**ADDENDUM NO. 5  
TO  
CONTRACT DRAWINGS AND SPECIFICATIONS  
Dated July 9, 2007**

**MAINE TURNPIKE AUTHORITY  
ADMINISTRATIVE BUILDING  
CONTRACT NO. 2007.07**

**Date of Addendum Issuance: August 17, 2007**

SUBJECT: FIRST FLOOR
SYSTEMS PLAN

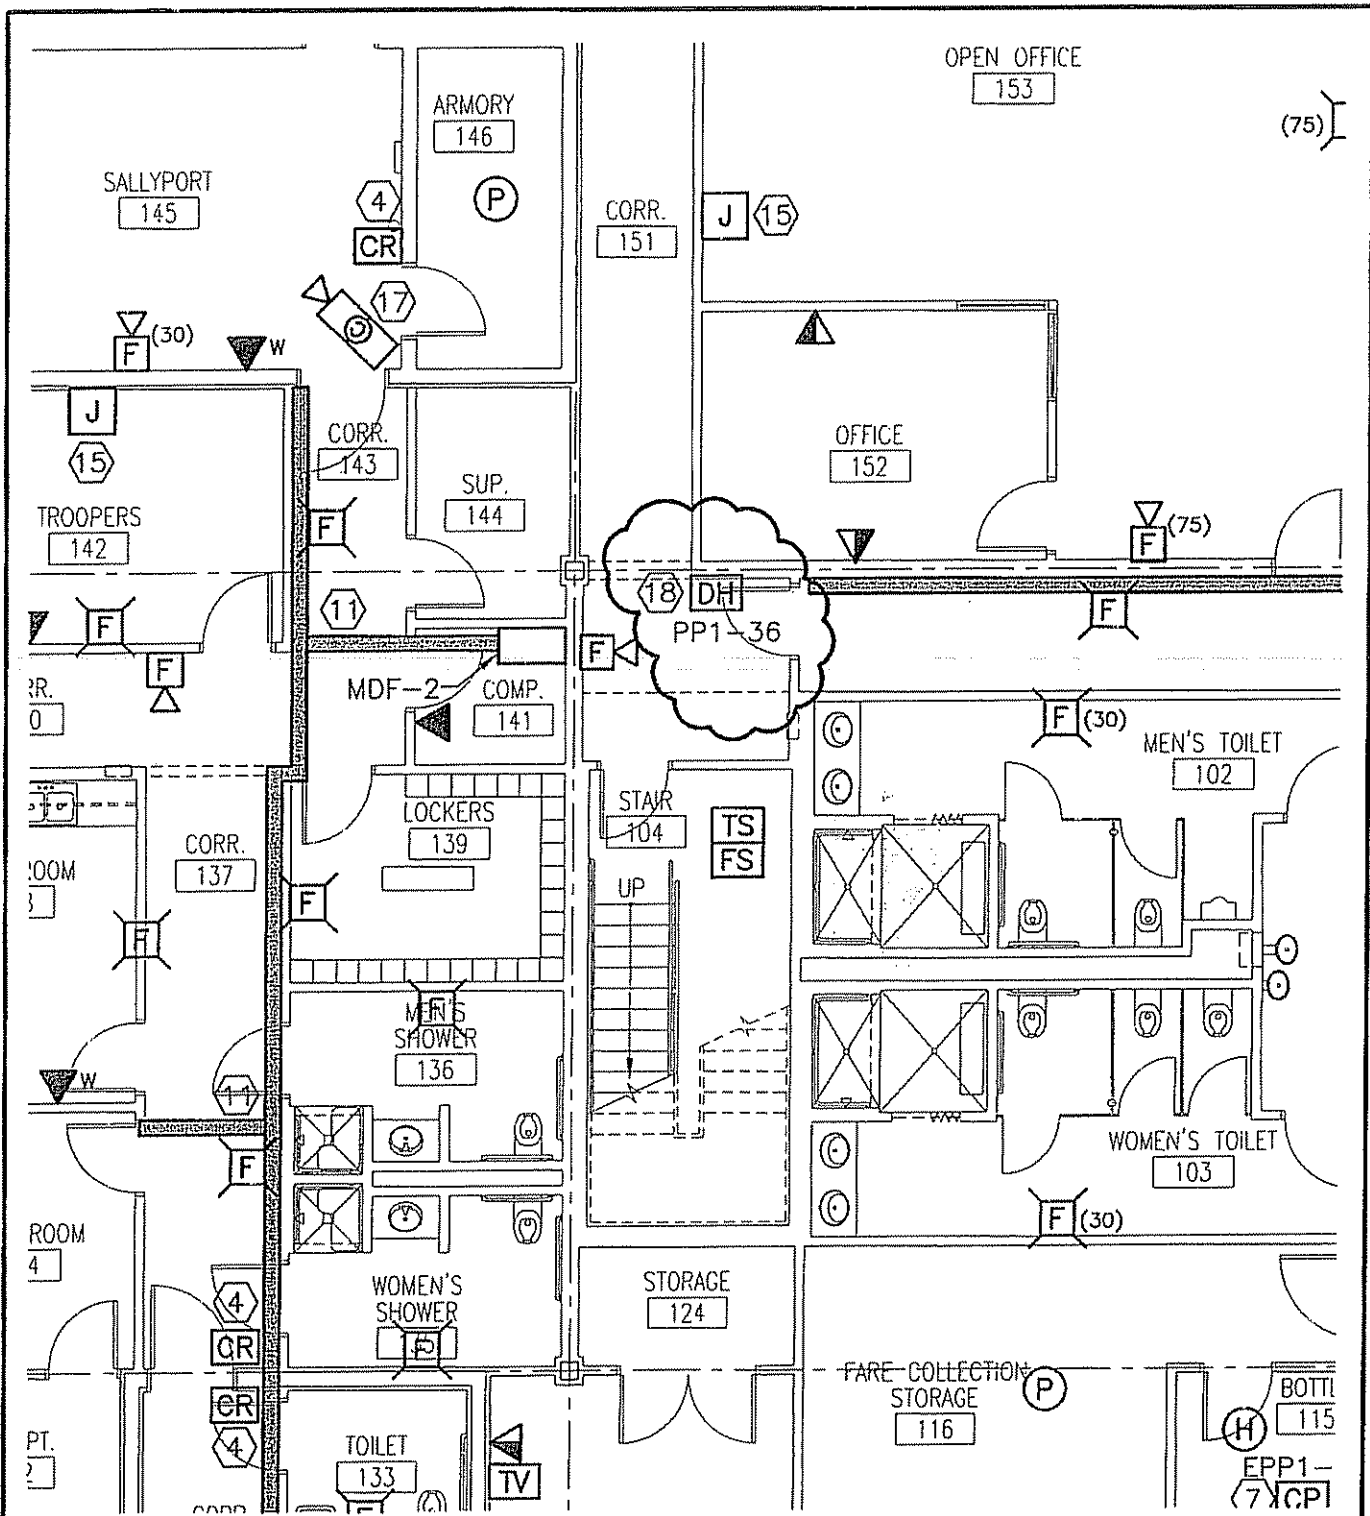
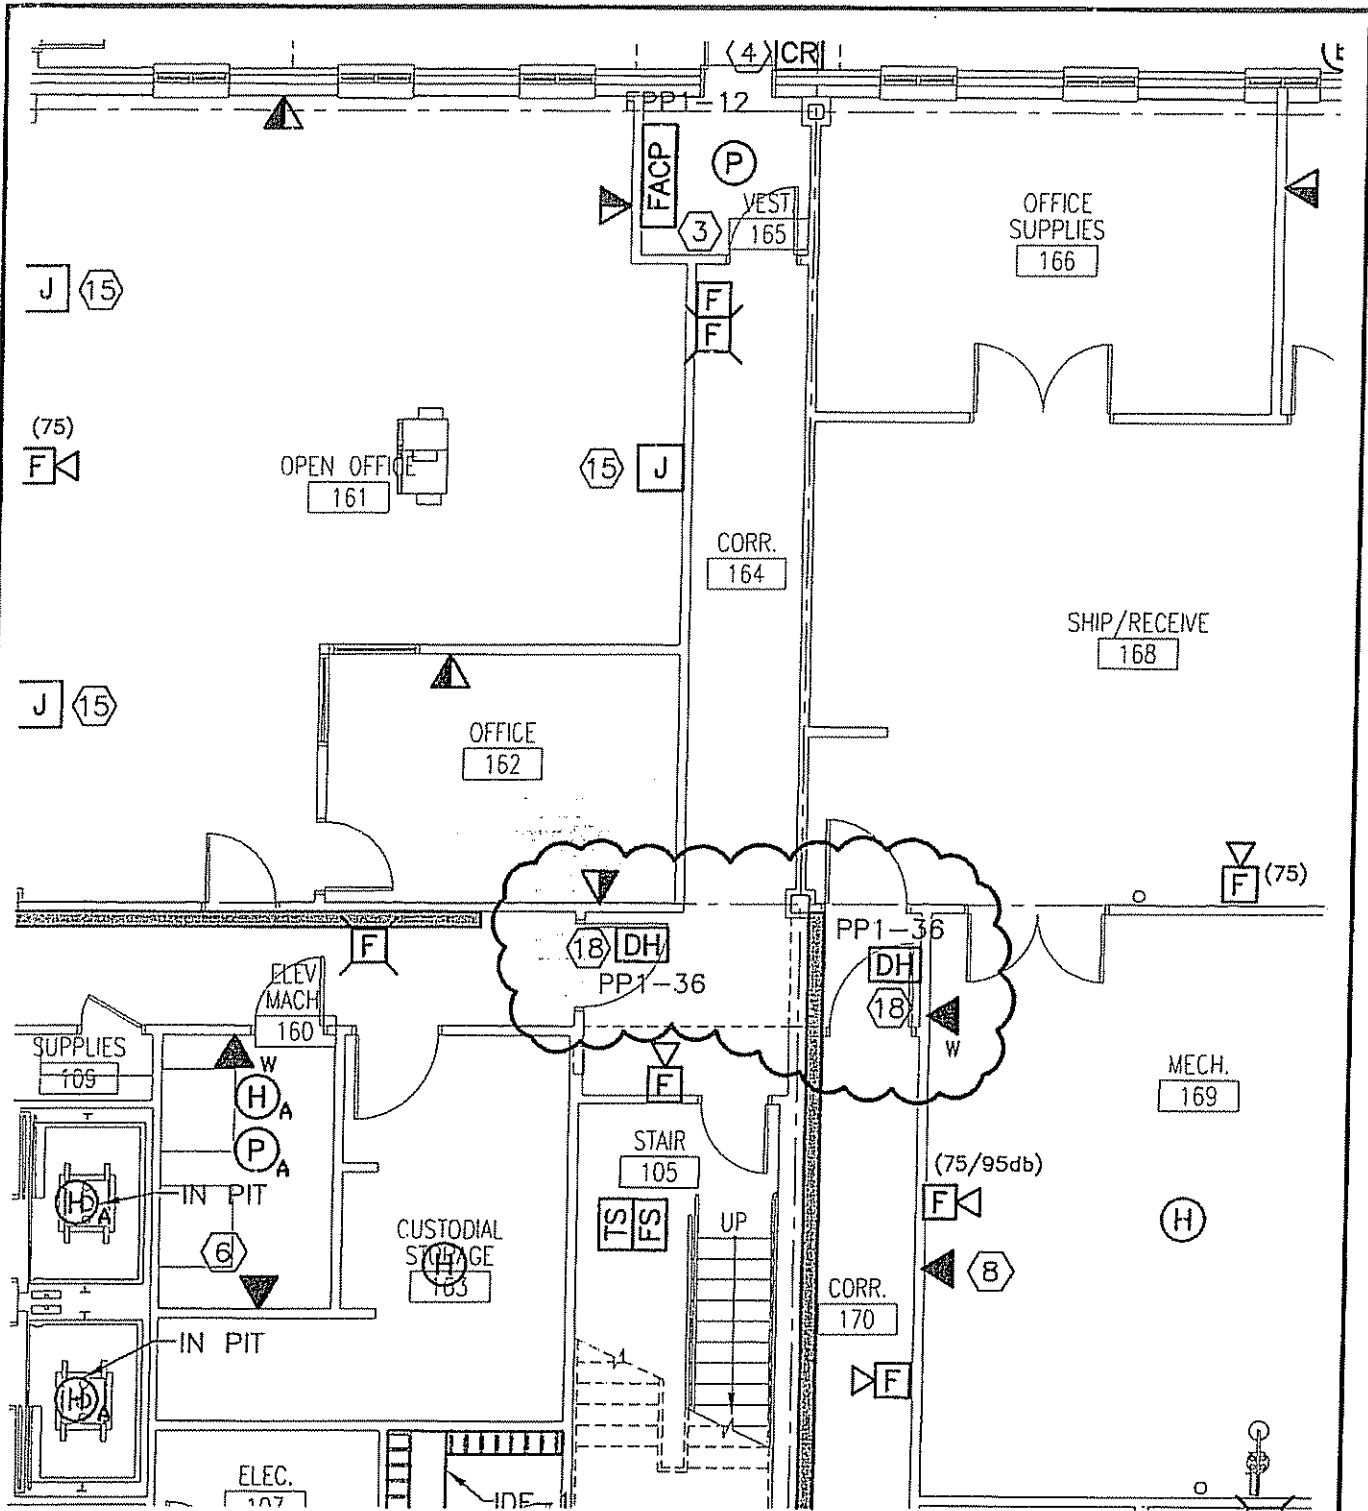
- a. Revise Keyed Note 13 to read as follows: “Exterior CCTV Camera location recessed in canopy. furnish and install 4” square weatherproof junction box with ¾” conduit and pullstring stubbed to above accessible ceiling inside the building for use by owner’s CCTV contractor. Coordinate exact location and mounting with owner, architect and CCTV contractor.” This direction shall supercede all prior direction given in the bidding documents, including prior addendum.

- b. Revise Keyed Note 17 to read as follows: “Interior wall mount CCTV Camera location. Furnish and install 4” square junction box with ¾” conduit and pullstring stubbed to above accessible ceiling for use by owner’s CCTV contractor. Coordinate exact location and mounting with owner, architect, and CCTV contractor.” This direction shall supercede all prior direction given in the bidding documents, including prior addendum.
